WELWYN HATFIELD BOROUGH COUNCIL – DEVELOPMENT MANAGEMENT
DELEGATED REPORT

APPLICATION No: 6/2015/2061/HOUSE

SITE ADDRESS: 97 The Ridgeway, Northaw, EN6 4BG

DESCRIPTION OF DEVELOPMENT: Erection of two storey rear extension and first floor side extensions and alterations to roof

Side Elevation (West)

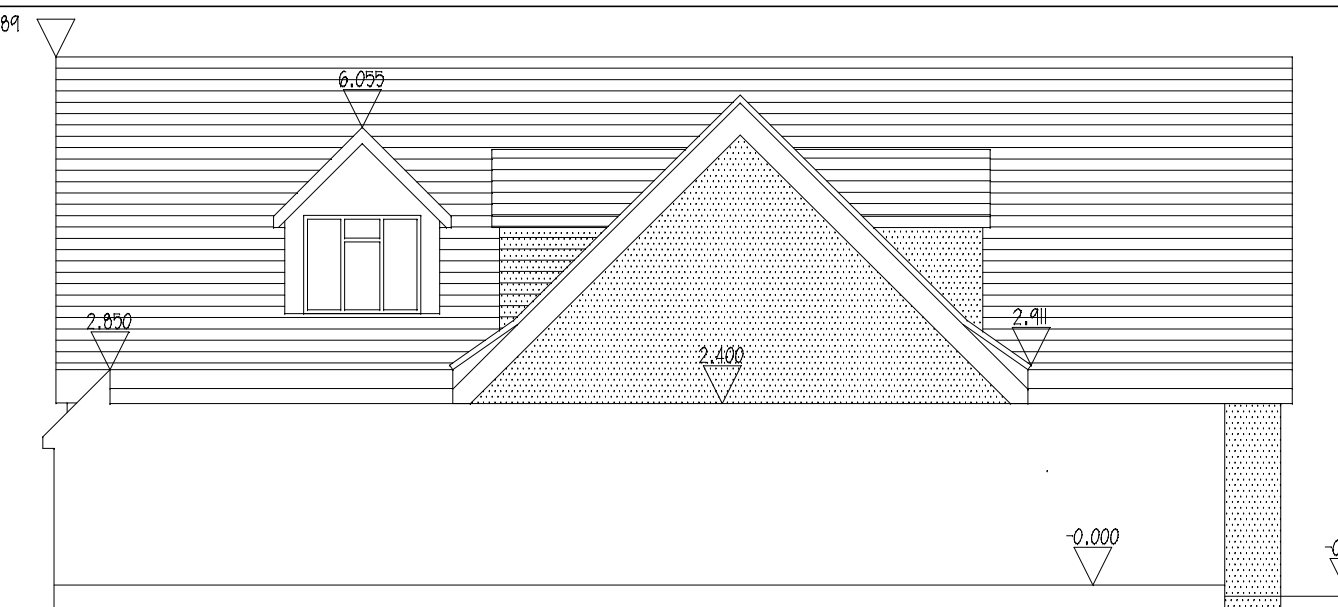
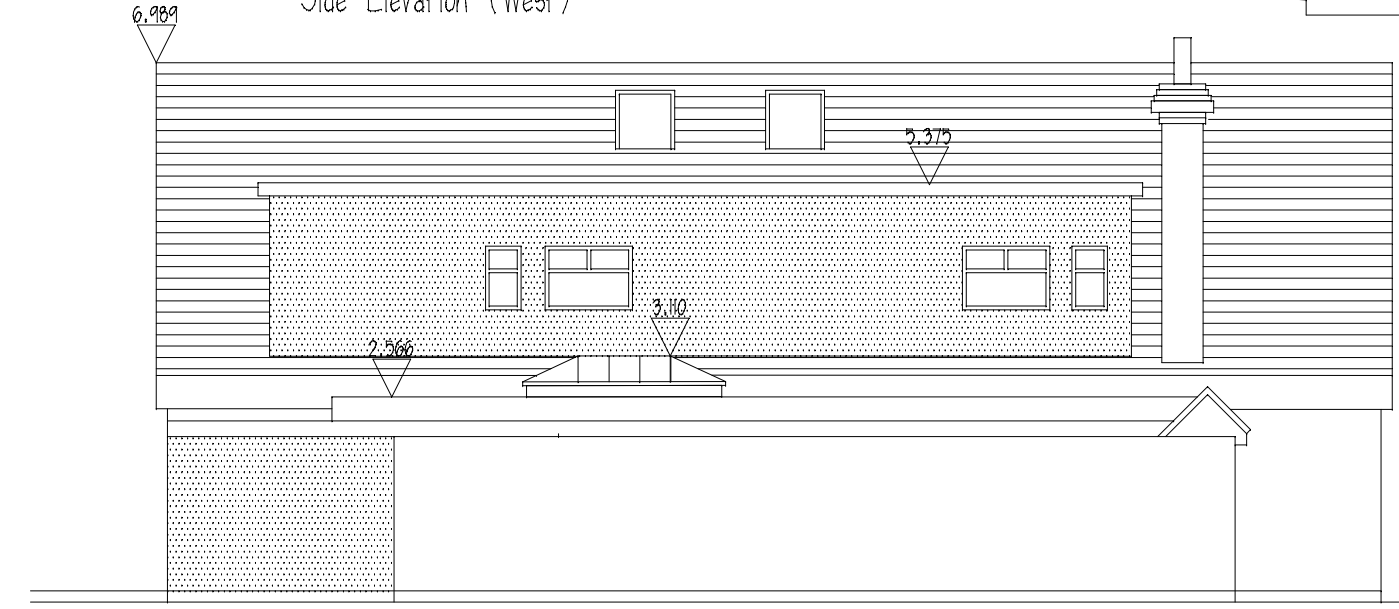
The proposed roof extension on the west elevation would project sideways beyond the eaves of the original roof by 1.8m. It would be 0.5m higher than the other dormer on this elevation and would contain one front and one rear windows. The ridge of this extension would be set down from the main ridge by 0.5m. It would present a flat end gable to the west elevation with the visual gap from the side boundary with No 99 being reduced from 4m to 2.2m. The width of this roof extension has been reduced by a metre as a result of Officer negotiations to preserve an adequate space to the side in keeping with the pattern of development in the vicinity. In addition it is set back 5m from the front edge of the main roof. A substantial space between the roofs of No's 97 and 99 would remain. When viewed from the west along The Ridgeway the proposed roof extension would be screened by the conifers on the front of the site boundary with No 99. However, these trees are not covered by TPOs and could be lost through disease or removed. If this were the case it is considered that the space between the roofs of No's 97 and 99 would be sufficient to preserve the visual space between the buildings and to preserve the openness of the Green Belt in this location.

The proposed western roof extension would replace one of the dormer windows and would project towards the boundary with No 99. The side elevation of No 99 facing this boundary is set some metres off the boundary and is screened from the road by a wall creating an enclosed courtyard. The proposed roof extension would present an end gable set 2.2m in from the boundary. The proposed roof extension has been reduced in width and height from the original proposal and is now of a design and scale that would not result in an overbearing impact or a significant loss of sun and daylight to the side elevation of No 99.

The existing bedroom dormers in the west roof plane face directly onto the side elevation and the courtyard of No 99. The proposed roof extension would replace one of these windows and create windows facing front and rear. This would represent an improvement in terms of privacy and overlooking for No 99.

Roof Plan

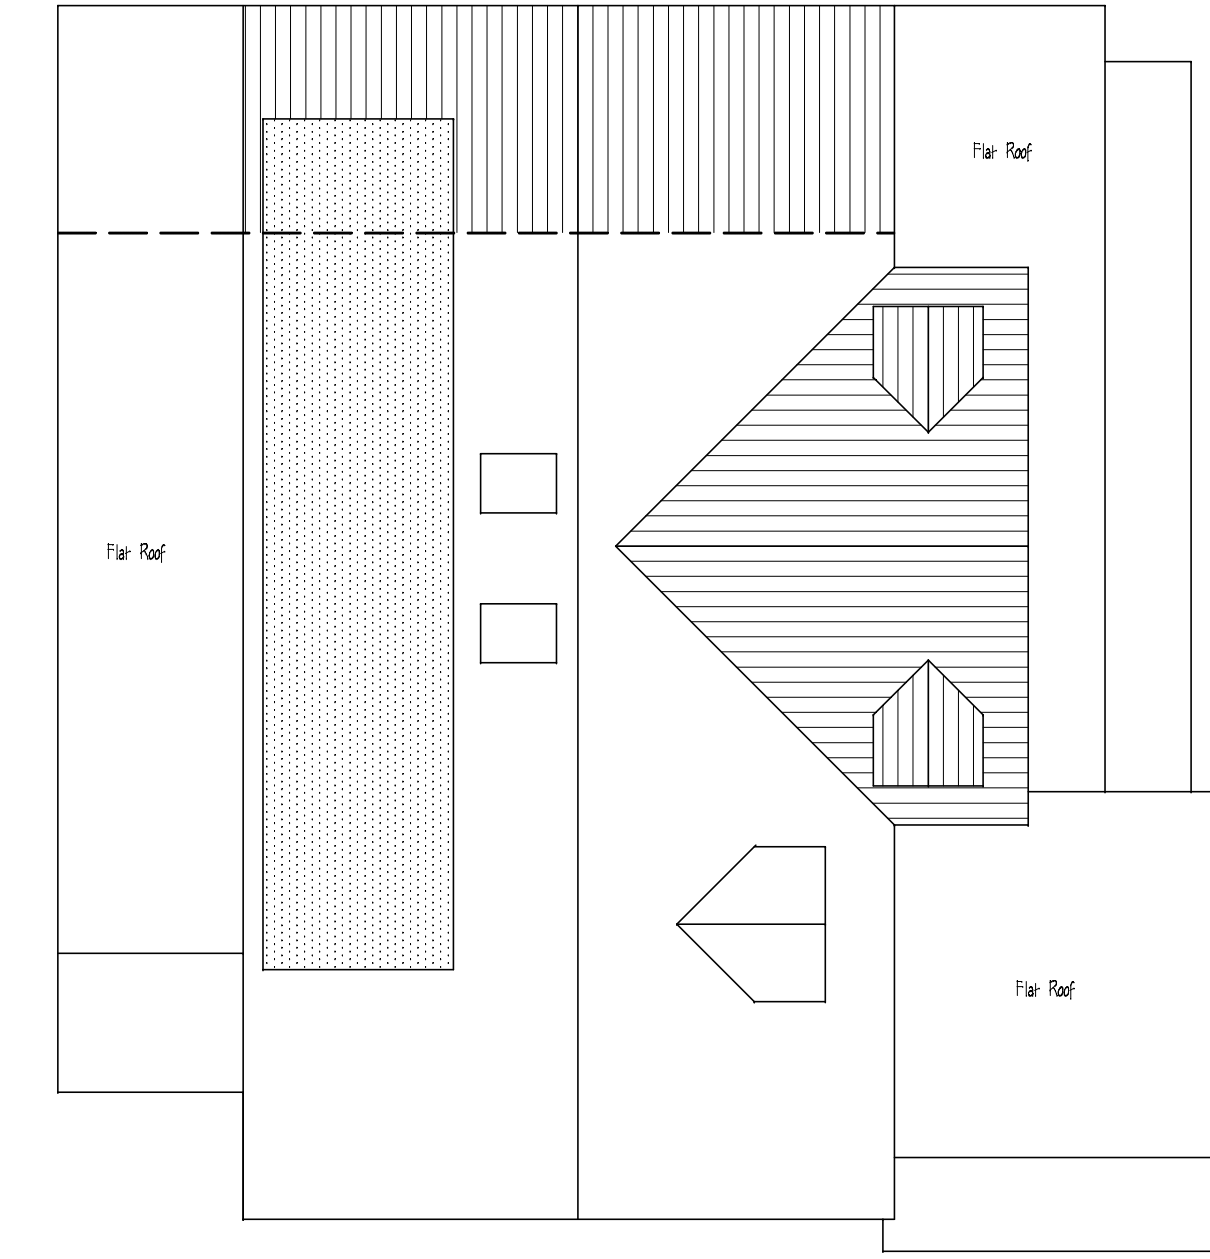
The proposed dormer in the east elevation would be lower than the existing pitched roof dormer. It would be set back from the front edge of the roof by 3.5m and down further from the main ridge by 1.6m than the existing dormer (which is the same height as the main ridge) and would not project any further to the side than the existing dormer. It would be 12m long (compared to the existing 3.3m). However, when viewed from the street in front of the house its bulk would appear less than the existing dormer and when viewed from along the road to the east its length would be partially concealed by the roof-scape of the adjacent house at No 95. Careful selection of materials for the external surfaces of the dormer would be a key in minimising the visual impact of this dormer. Tiles to match the existing roof would be required on the external faces and this can be secured by condition.

The proposed dormer on the eastern roof plane would introduce two additional windows to this elevation. However, these would be small and serve a bathroom and WC. In order to prevent overlooking of the conservatory roof and patio at No 95 a condition shall be imposed on any planning permission requiring obscure glazing and fixed lights up to 1.8m above the internal floor level.

The two roof-lights in the eastern roof plane would be above the landing area and have sill heights above 1.8m above the internal floor level. Thus they would not give rise to an increase in overlooking of No 95.

4. The roof lights and windows in the east elevation of the dormer of the extensions/alterations hereby permitted shall be glazed with obscured glass and shall be fixed so as to be incapable of being opened below a height of 1.8 metres above floor level, and shall be retained in that form thereafter.

Rear Elevation (South)

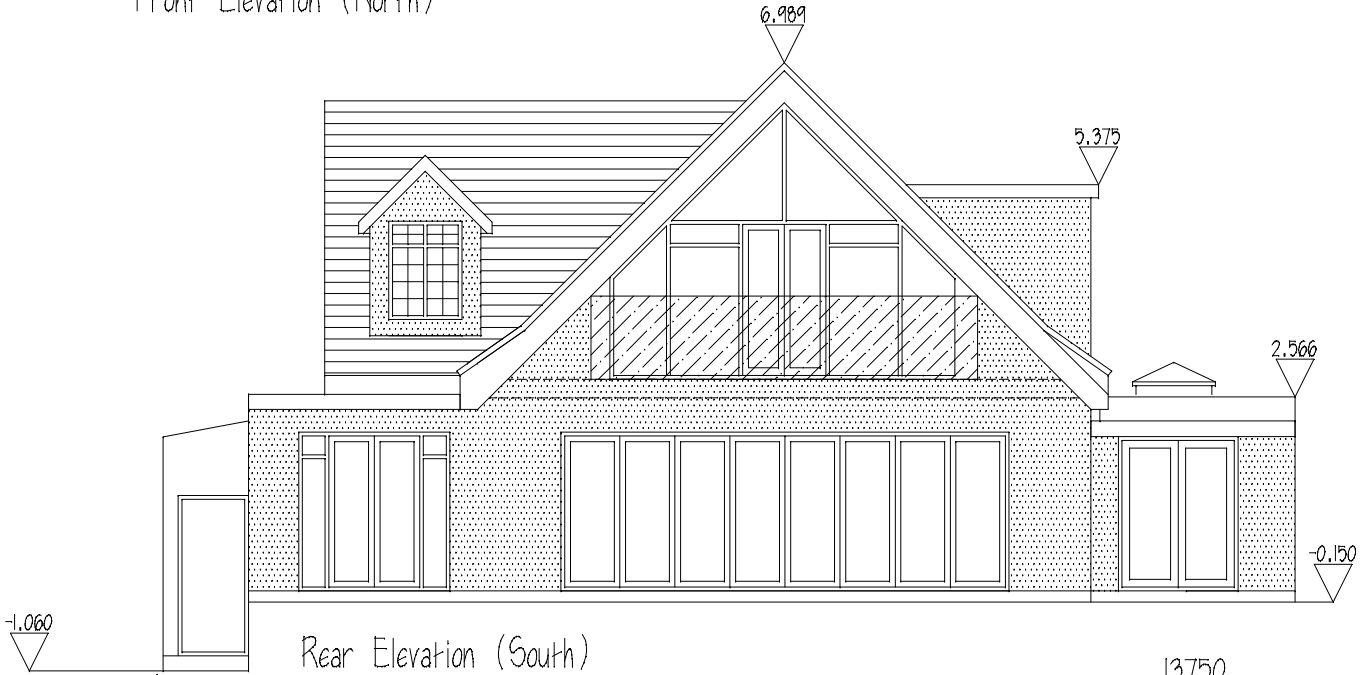
The main house at No 99 has been extended so that the flat roofed side extensions abut the boundary and are as deep as the existing lounge at No 97 (which was a previous side extension projecting 2.5m beyond the rear wall of the original house). The proposed rear extension would project 0.5m beyond the rear elevation of No 95, be single storey and be set in from the boundary by 1.1m. As such the proposed rear extension would not result in an overbearing impact on the property at No 99 and be unlikely to result in loss of sun or daylight to principal windows in its rear elevation.

The proposed windows in the rear elevation of the rear extension would be larger than the existing ones and include a Juliet balcony set within the rear elevation in the

roof shape at first floor. However, these would face directly down the garden of the application site and would not create a significant increase in overlooking of neighbouring gardens.

Proposed Site Plan

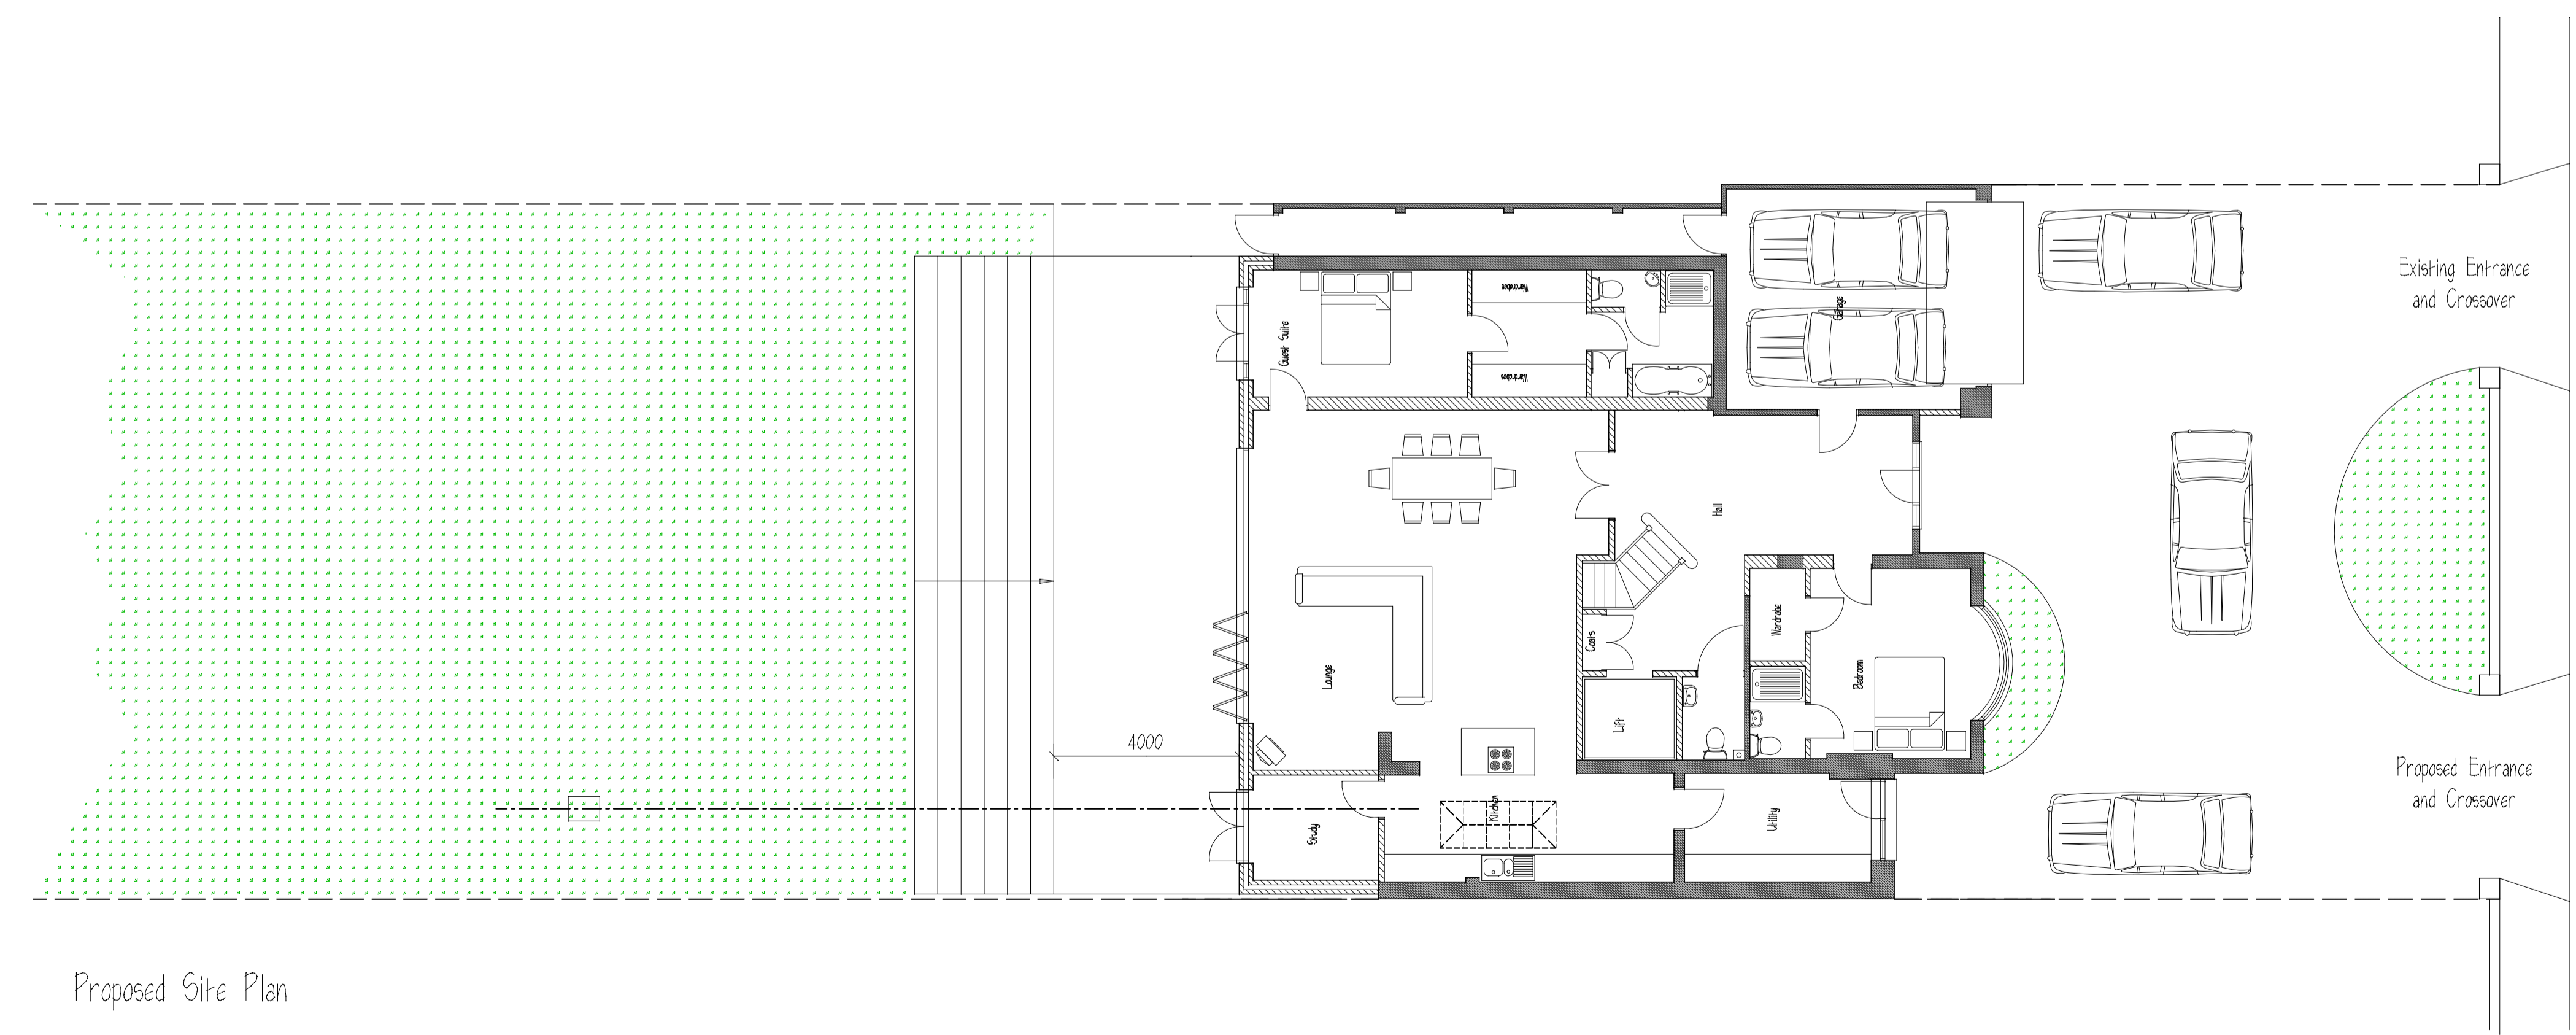
The existing house has an attached double garage which would be retained. In the front garden there is a hard-standing that accommodates three cars. The increase in the number of bedrooms at the property from three to four/five would increase the demand for parking on the site from 2.25 spaces to 3 spaces. The creation of another vehicle access point to enable a carriage drive would not reduce the capacity of the drive to accommodate the required parking. The existing garage and parking capacity would be retained and are considered adequate to accommodate the on-site demand generated by the proposed extensions in accordance with the above policies.
